DOCUMENT CONTROL			
Revision	Date issued	Author	Notes
Rev01	12 June 2019	City of Sydney (SC)	Comments and markups to Strategy submitted with SSD 9694

301 and 305 Kent Street and 35–39 Erskine Street, Sydney

Design Excellence Strategy

KENT STREET HOTEL | SOUTH ELEVATION

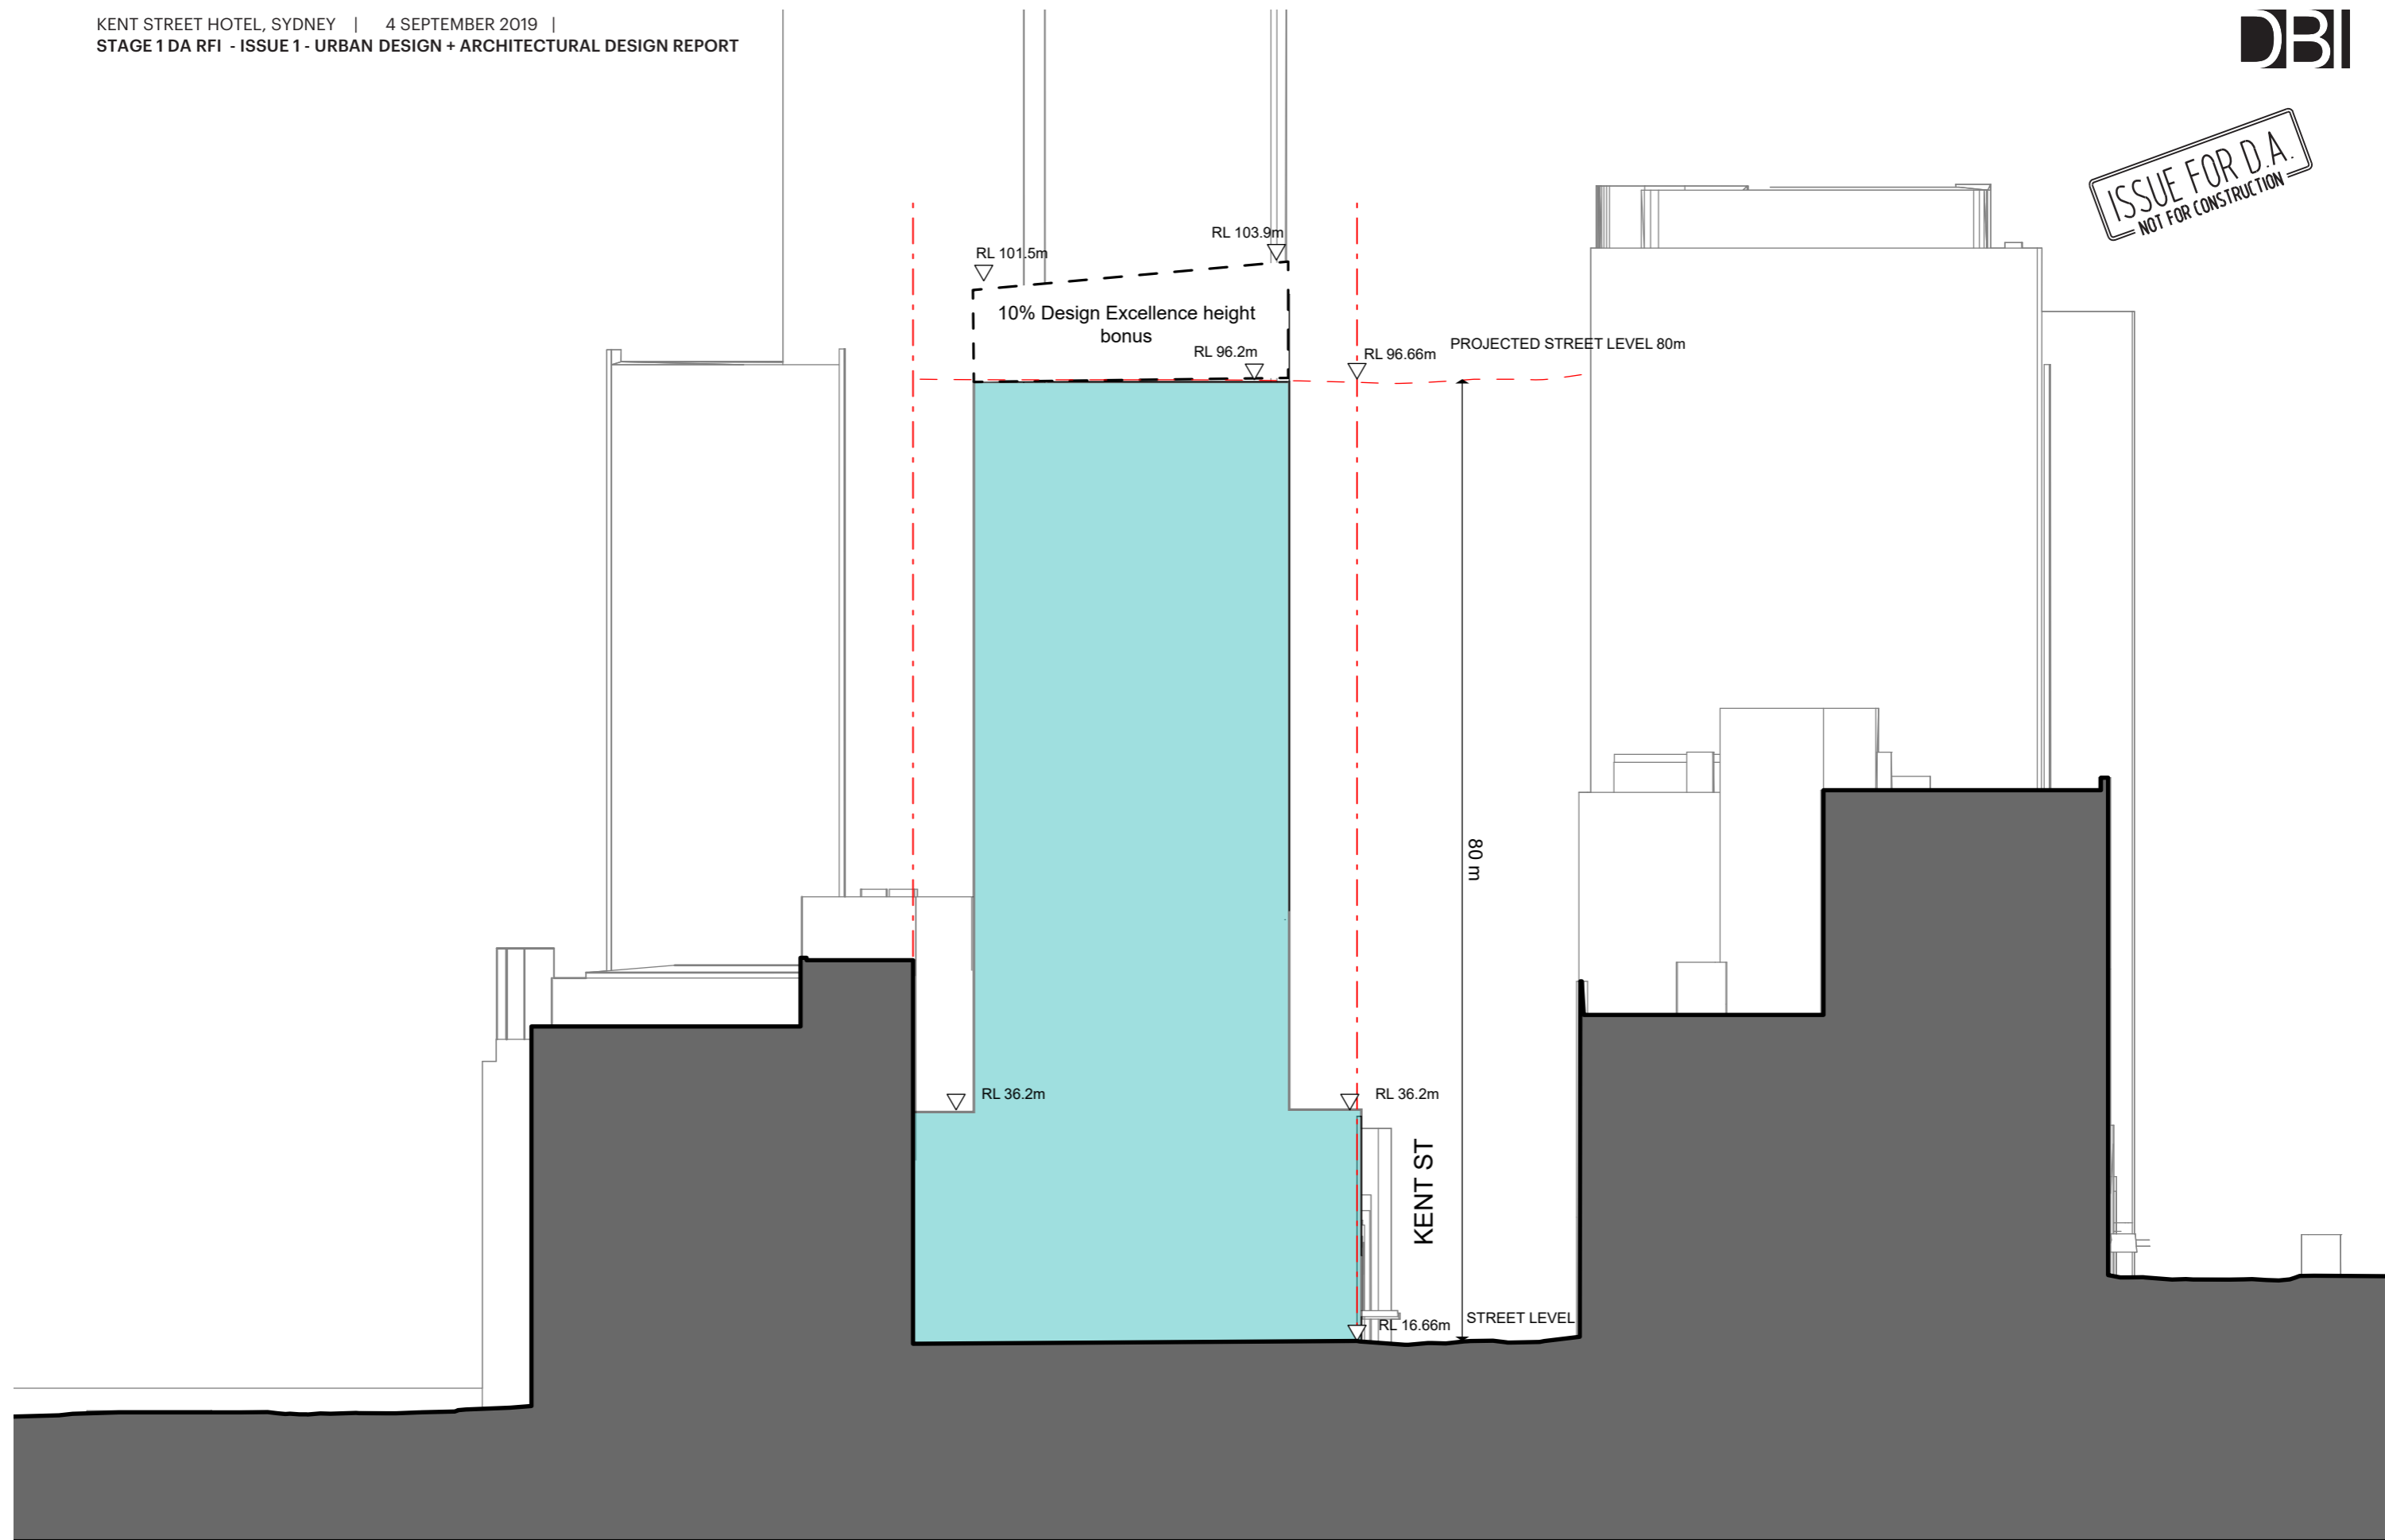
Commented [SC4]: The concept envelopes include the additional height (shown dotted) that may be awarded under 6.21 (7) of the Sydney LEP. In order for there to be no ambiguity about the extent of the approved envelope, any approval should include consent conditions that reference the approved height in RLs, being no greater than the maximum LEP height.
